About the application

Application number: 2023/90696	
What is the application for?:	Erection of detached dwelling
Address of the site or building:	adj, 2, Scopsley Green, Whitley, Dewsbury, WF12 0NF
Postcode:	WF12 0NF

User comments

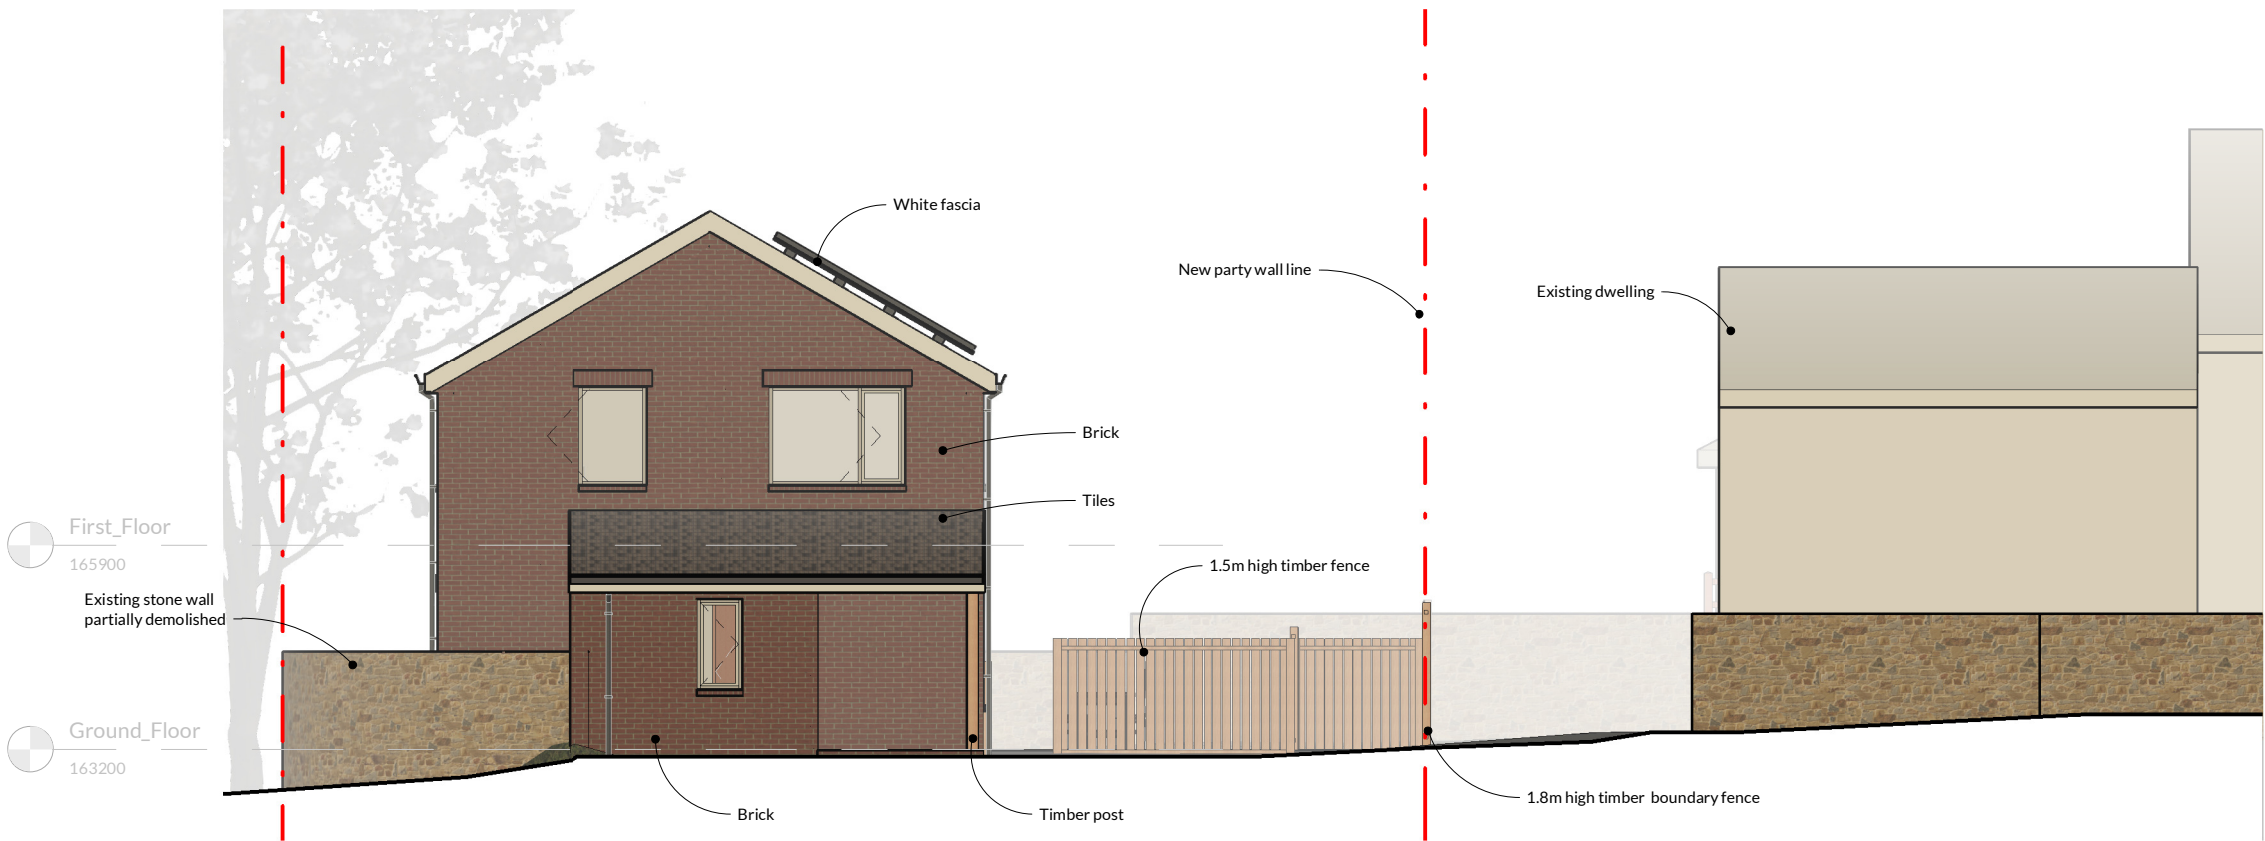
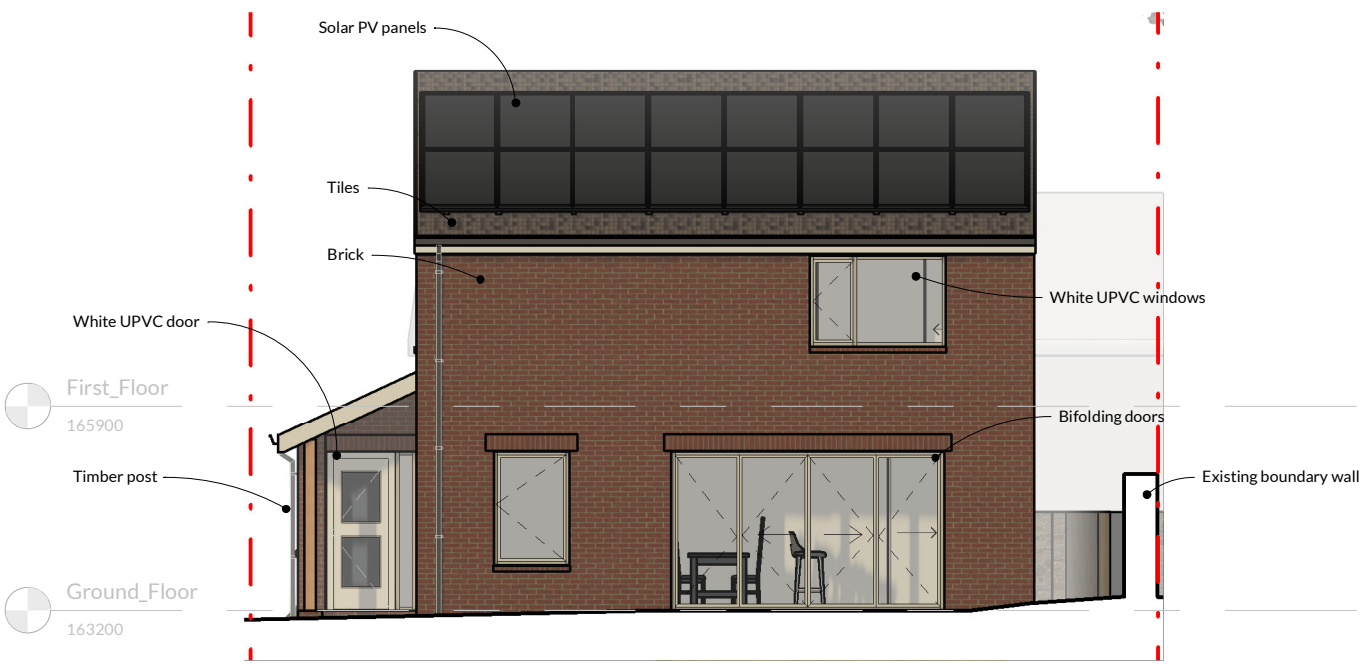
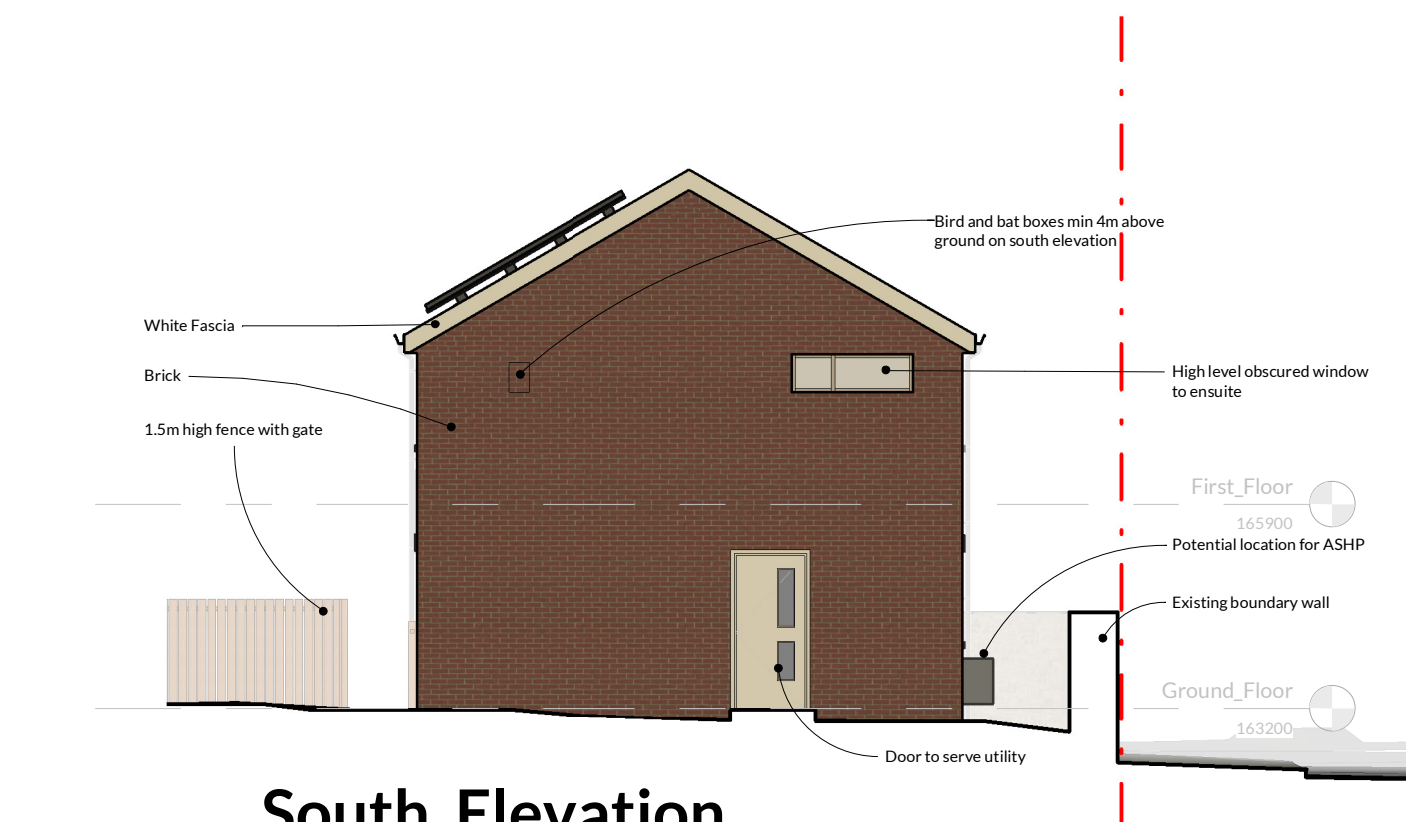
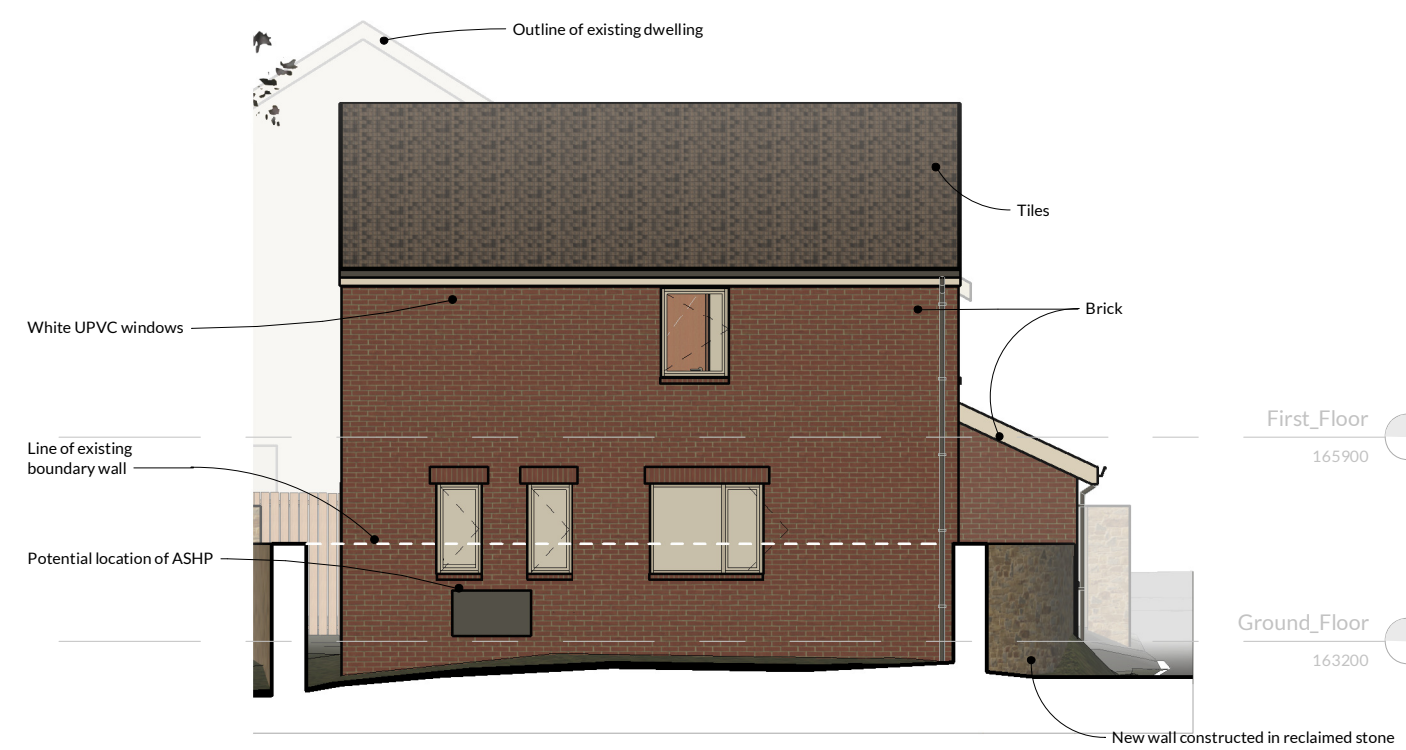
Type of comment: An objection	
Do you wish your comments to be published on the website anonymously?	Yes
Mr Dawkins told us he was planning to build a bungalow on the land, it is now a two story house and lean to. This will dominate our view and more importantly it will be overlooking our house with intrusion on our privacy. Already parked on site are 3 cars and 3 trailers. New residents will bring further vehicles. Additional street parking will occur causing more congestion on the narrow road. This part of Scopsley lane is a cul de sac and is already compromised with refuse wagons, delivery vehicles etc. we therefore are strongly opposed to the planning application.
